**RESPONSES TO EXAMINING AUTHORITY'S
QUESTIONS 20/12/18**

**ON BEHALF OF THE
HISTORIC BUILDINGS AND MONUMENTS COMMISSION FOR ENGLAND
(HISTORIC ENGLAND)
("HBMCE")**

**Application by
Highways England for an Order granting Development Consent for the A303
Sparkford to Ilchester Dualling**

PINS Reference No: SPIL-SP0005 & 2001-4933

© Crown Copyright and Database Right (2019)
 Ordnance Survey 100038382

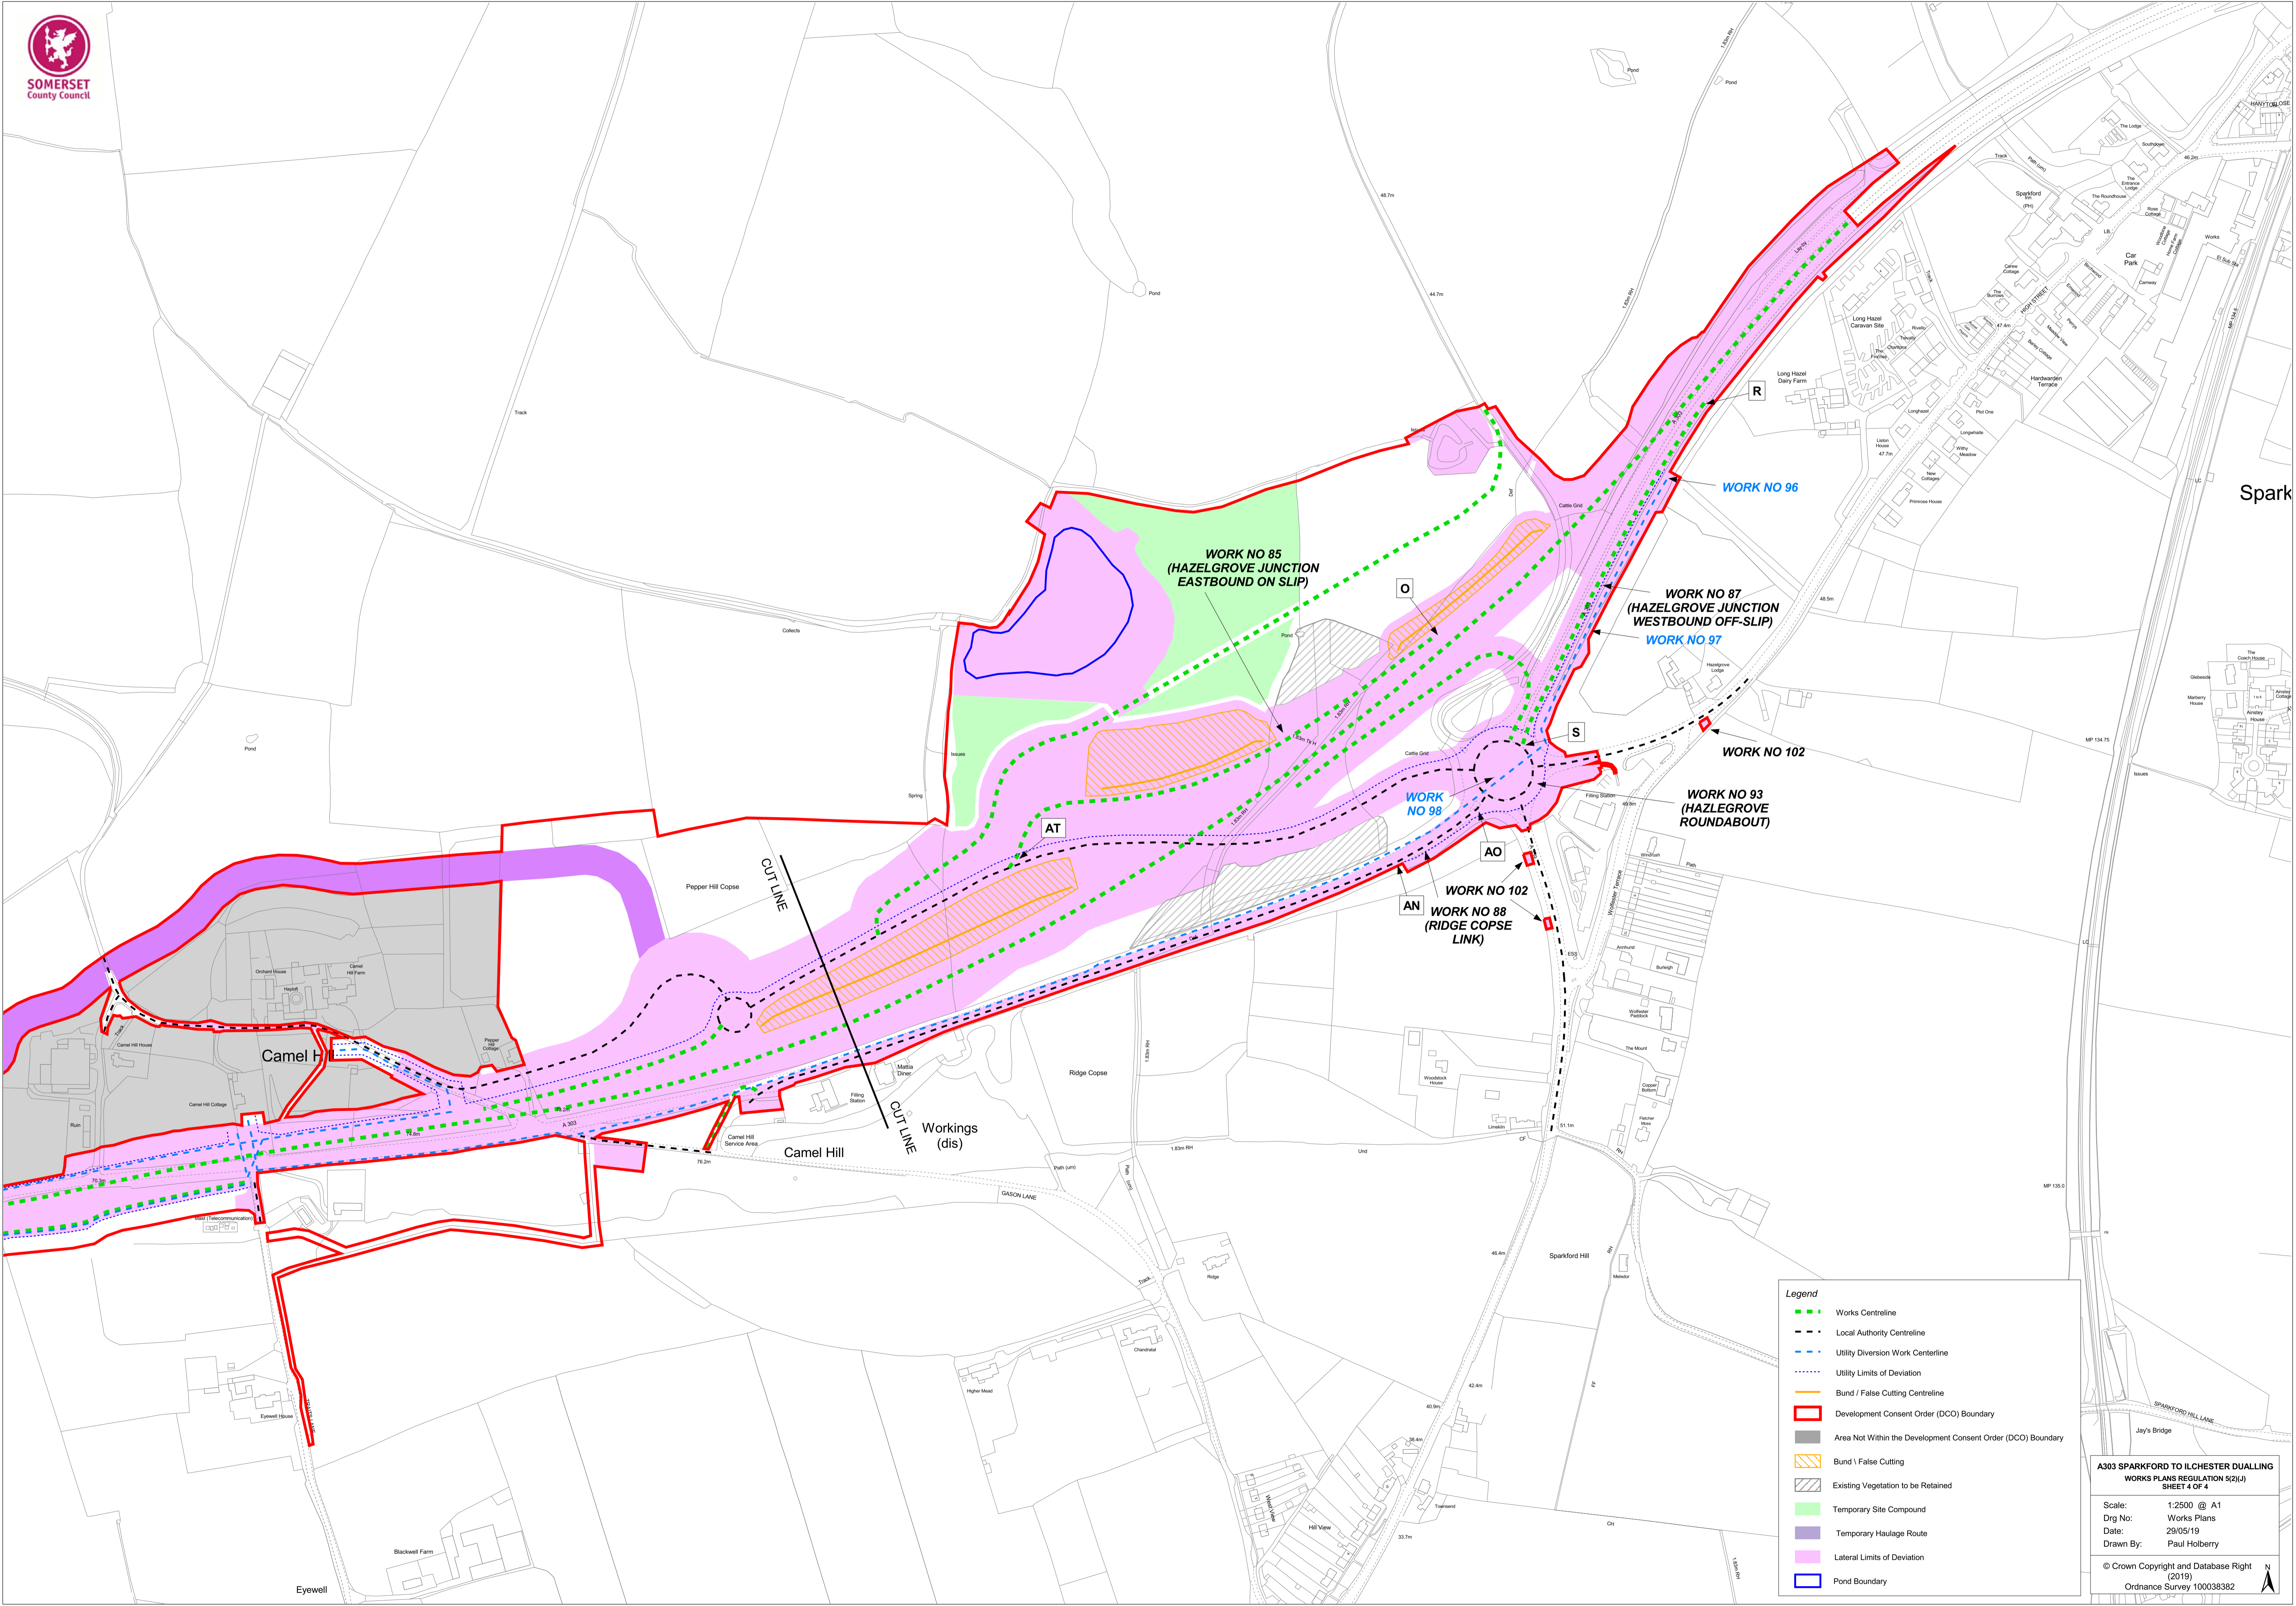
Can Historic England confirm which bund(s) as shown on the Works Plan [APP-006] it is referring to?

HBMCE response: Bunds 5, 6 and 7 (Work no.s 82, 89 and 90 respectively). Refer also to HBMCE Written Representation Section 7.5.3 (e) where the impact of the bunds in terms of screening is considered.

Figure 2.4 Auxiliary compound at Hazlegrove.

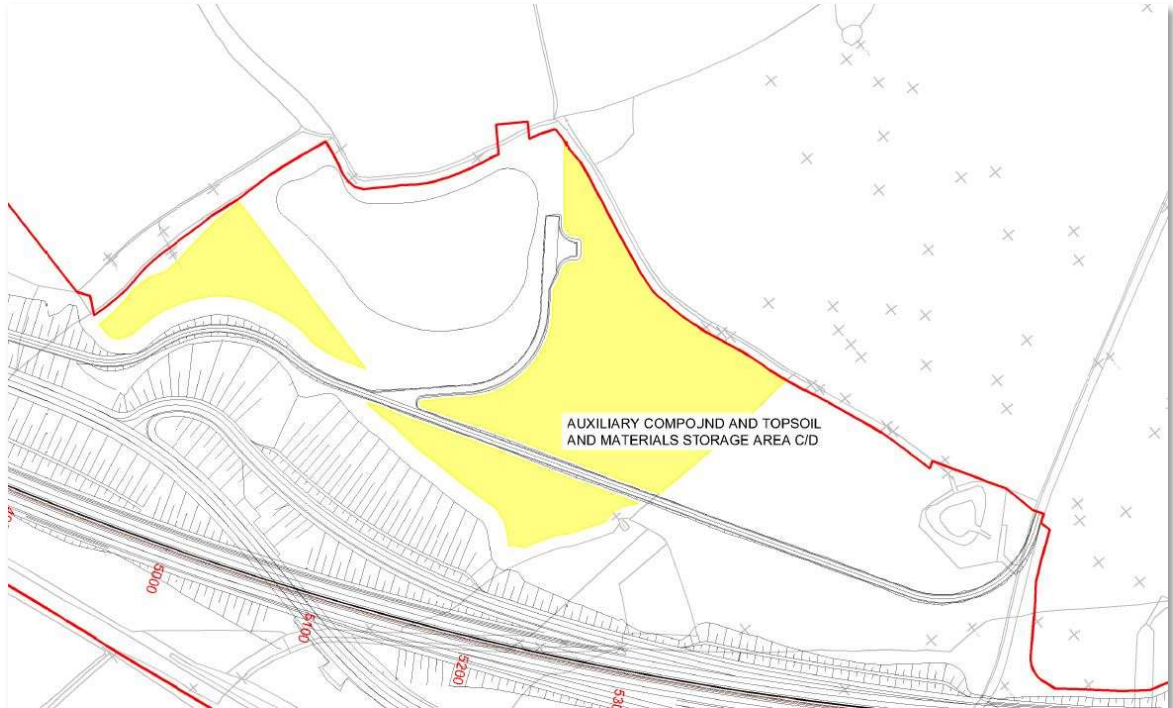
HBMCE response: HBMCE consider that although a construction compound and temporary soil stockpile area are referred to as being located in the RPG (ref. ES Chapter 6, para 6.9.13), they are not identified on the Works Plans or defined in the Temporary Construction Impact. We consider that further detail, including locations and extents, should be provided in the ES to inform the conclusions, including Table 7.2, and the Work Plans for the DCO, refer to HBMCE Written Representation Section 7.5.3 (c).

a) In Table 6.4, second row, of the Chapter 6 Cultural Heritage of the ES [APP-043] assessing the effects on the Hazlegrove House RPG there are references to a “construction compound” and an “ancillary construction compound”. However, these

are not shown on the works plan. Have they been omitted from the works plan or no longer proposed? b) Does the assessment set out in the ES need to be updated to take account of the final proposal?
